DELEGATED HOUSEHOLDER DECISION

Planning permission is sought for the erection a first floor extension to the side.

28612/APP/2023/972	6 LODORE GREEN ICKENHAM
Erection of a first floor extension to the rear of the dwelling.	
Decision:	Refused
28612/APP/2023/970	6 LODORE GREEN ICKENHAM
Erection of a single storey extension to the front	
Decision:	Refused
28612/APP/2020/444	6 LODORE GREEN ICKENHAM
First floor side extension, single storey side/rear extension, conversion of garage to habitable use, porch to front and alterations to elevations	
Decision: 15-04-2020	Approved
28612/APP/2020/78	6 LODORE GREEN ICKENHAM
Erection of a single storey rear extension, which would extend beyond the rear wall of the original house by 4 metres, for which the maximum height would be 3 metres, and for which the height of the eaves would be 2.95 metres	
Decision: 10-02-2020	Prior Approval N/Req
28612/APP/2019/3785	6 LODORE GREEN ICKENHAM
First floor side extension, single storey rear extension, single storey front extension, enlargement of porch and conversion of garage to habitable use

Proposed first floor

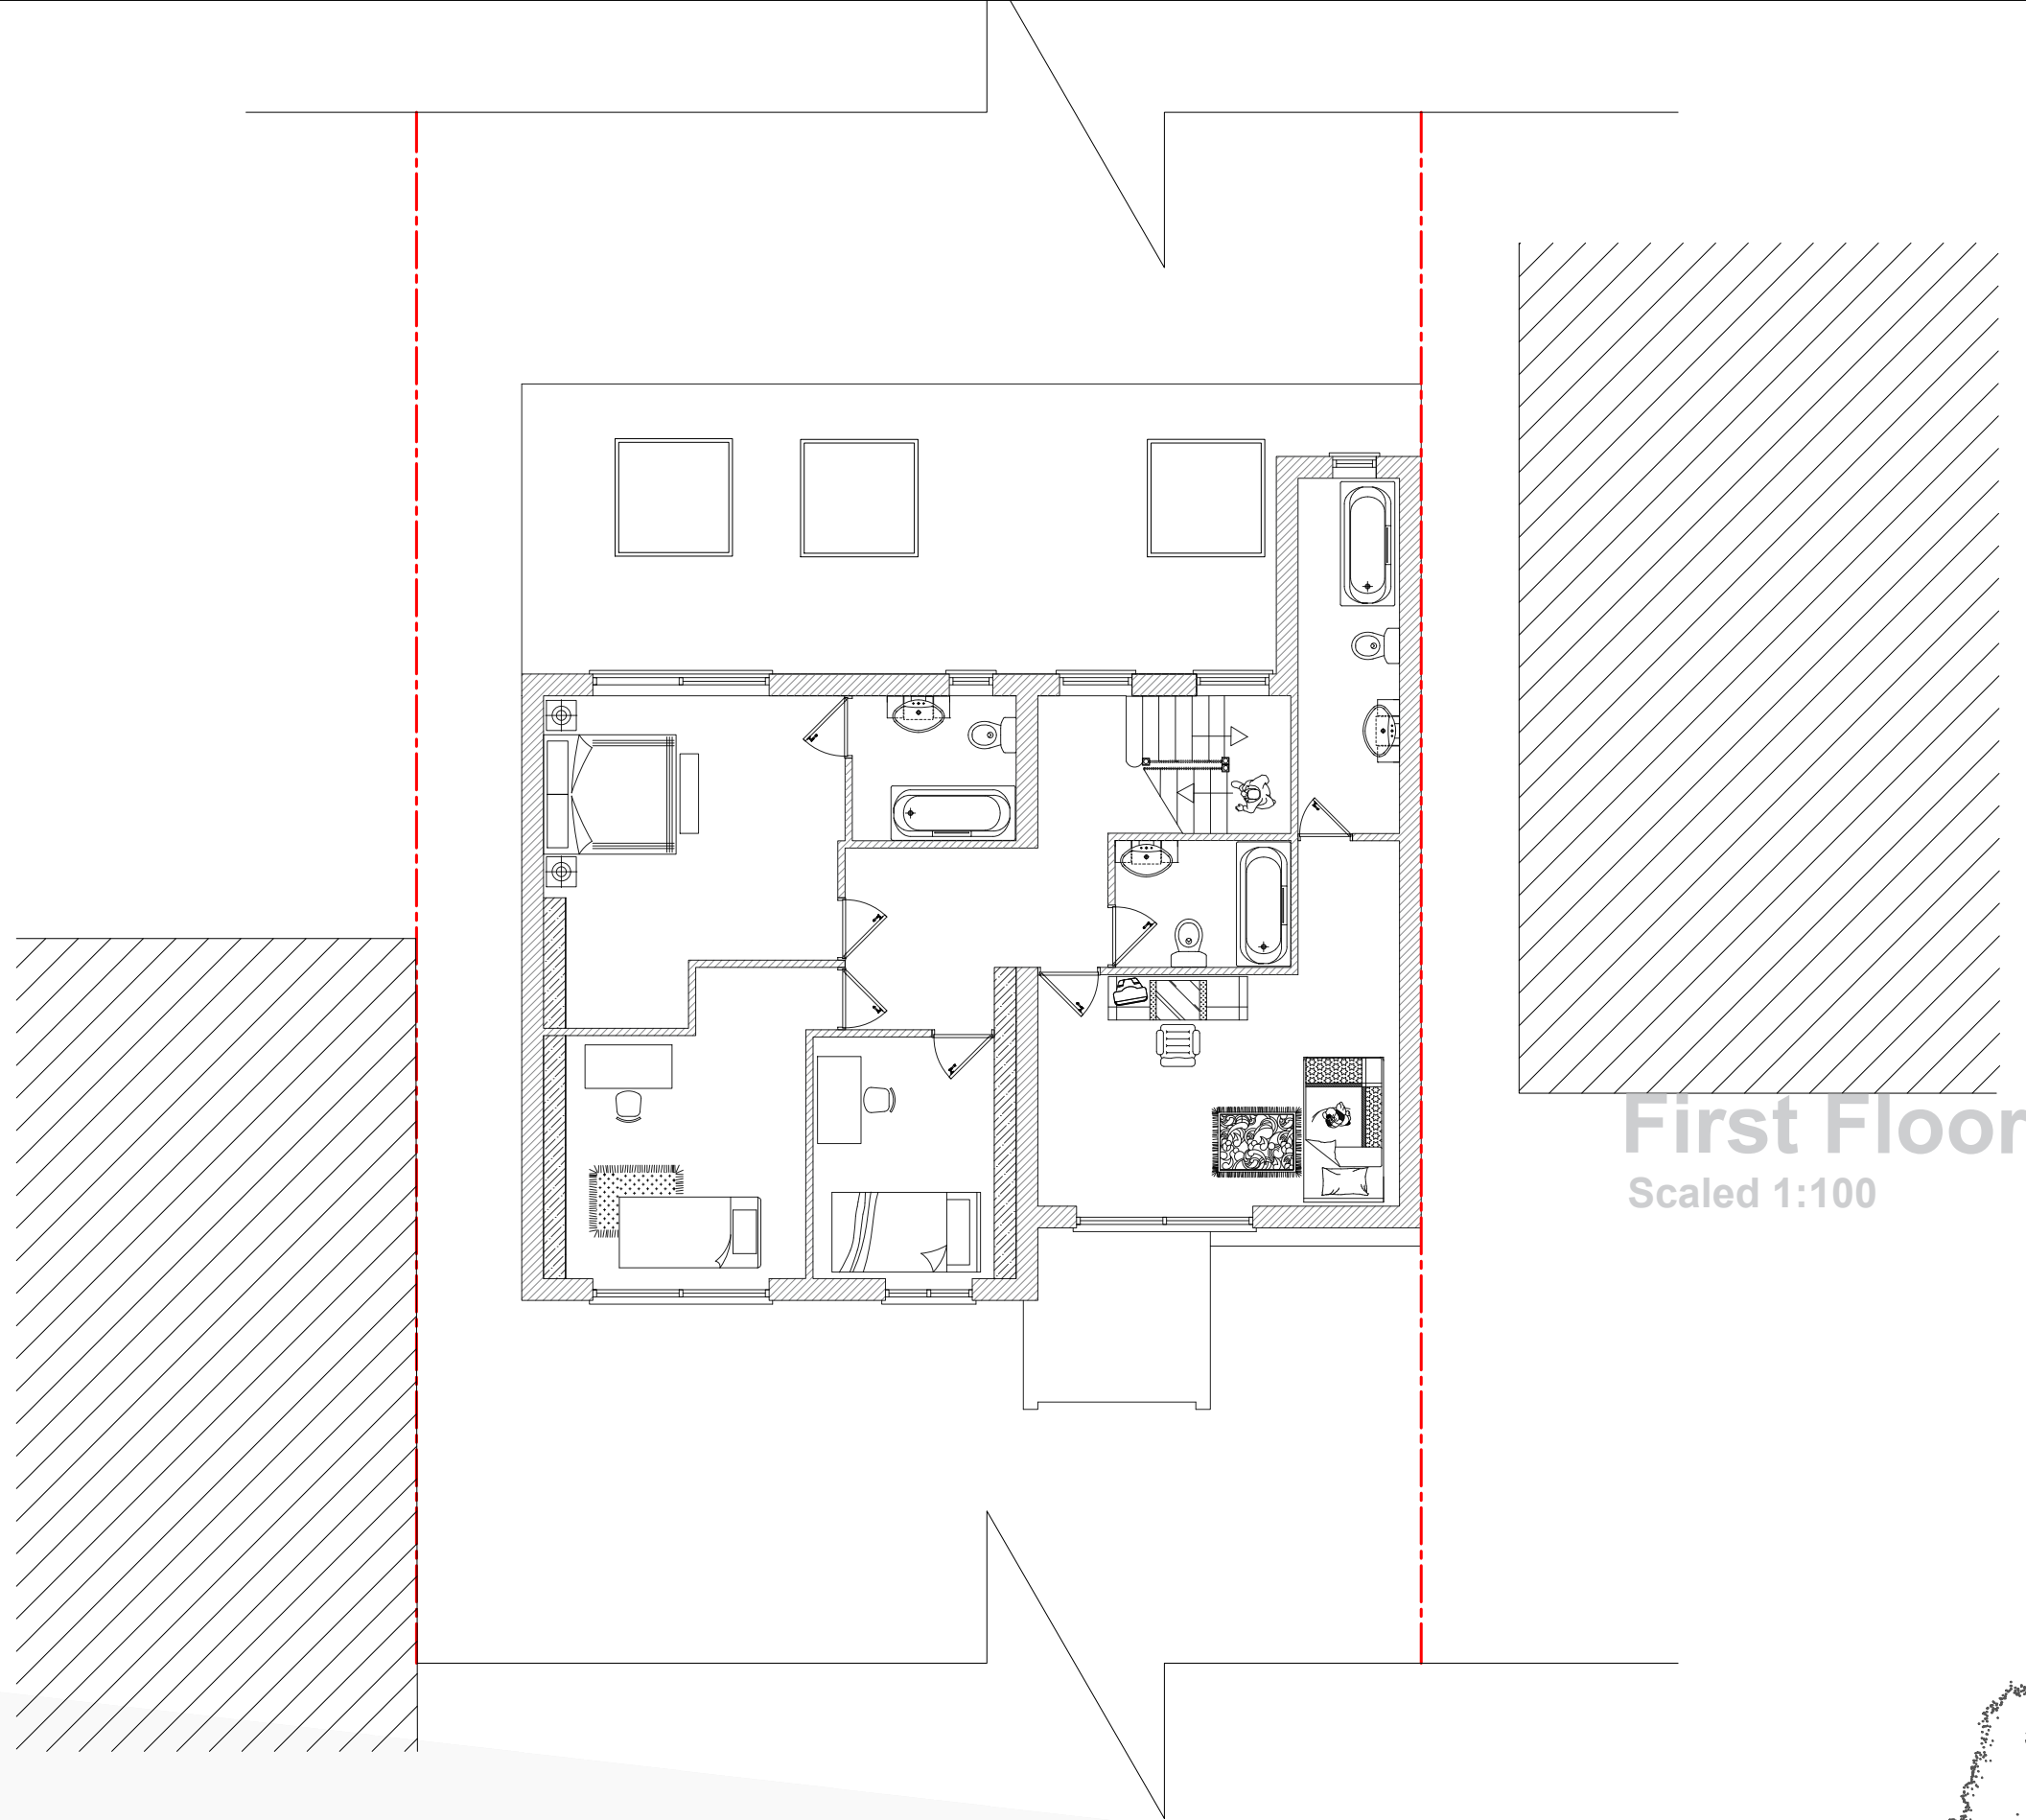
The proposed first floor extension to the side and rear will measure a depth of 1.5m, a length of 10.7m and will feature a shallow hipped roof along the side elevation. Towards the rear, the extension will protrude 3m beyond the first floor rear building line, and whilst it would have a modest depth to the rear, it would result in an awkward narrow pitched roof along the rear elevation. In culmination with the existing first floor side extension, the total depth of the side extension is

approximately 5.7m. The proposed development fails to comply with Policy DMHD 1 as it exceeds half the width of the original property (in combination with the existing), would be built up right to the boundary and not set in 1m from the side boundary at first floor level. Whilst it would be set in 1m from the front building line, this would not mitigate the harm caused to the character and appearance of the host dwelling nor the surrounding area.

By virtue of the additional first floor side and rear extension, the proposal would result in a closing of visually open gap at first floor level between the application site and the neighbouring property at No. 7 Lodore Green, giving rise to a cramped form of development and possible terracing effect, which would be detrimental to the visual amenities of the street scene and the surrounding area generally. The proposal is therefore contrary to Policy BE1 of the Hillingdon Local Plan: Part One - Strategic Policies (November 2012) and Policies DMHB 11 and DMHD1 of the Hillingdon Local Plan: Part Two - Development Management Policies (January 2020). The first floor rear, whilst modest in size would appear at odds with the host dwelling and result in an incongruous roof form.

The proposed first floor side and rear extension, by reason of its size, scale, bulk and proximity to the side boundary, would result in an incongruous roof form, the closing of the visually open gap between it and the neighbouring property, 7 Lodore Green, giving rise to a cramped form of development and possible terracing effect, which would be detrimental to the visual amenities of the street scene and the surrounding area generally. The proposal is therefore contrary to Policy BE1 of the Hillingdon Local Plan: Part One - Strategic Policies (November 2012) and Policies DMHB 11 and DMHD1 of the Hillingdon Local Plan: Part Two - Development Management Policies (January 2020)
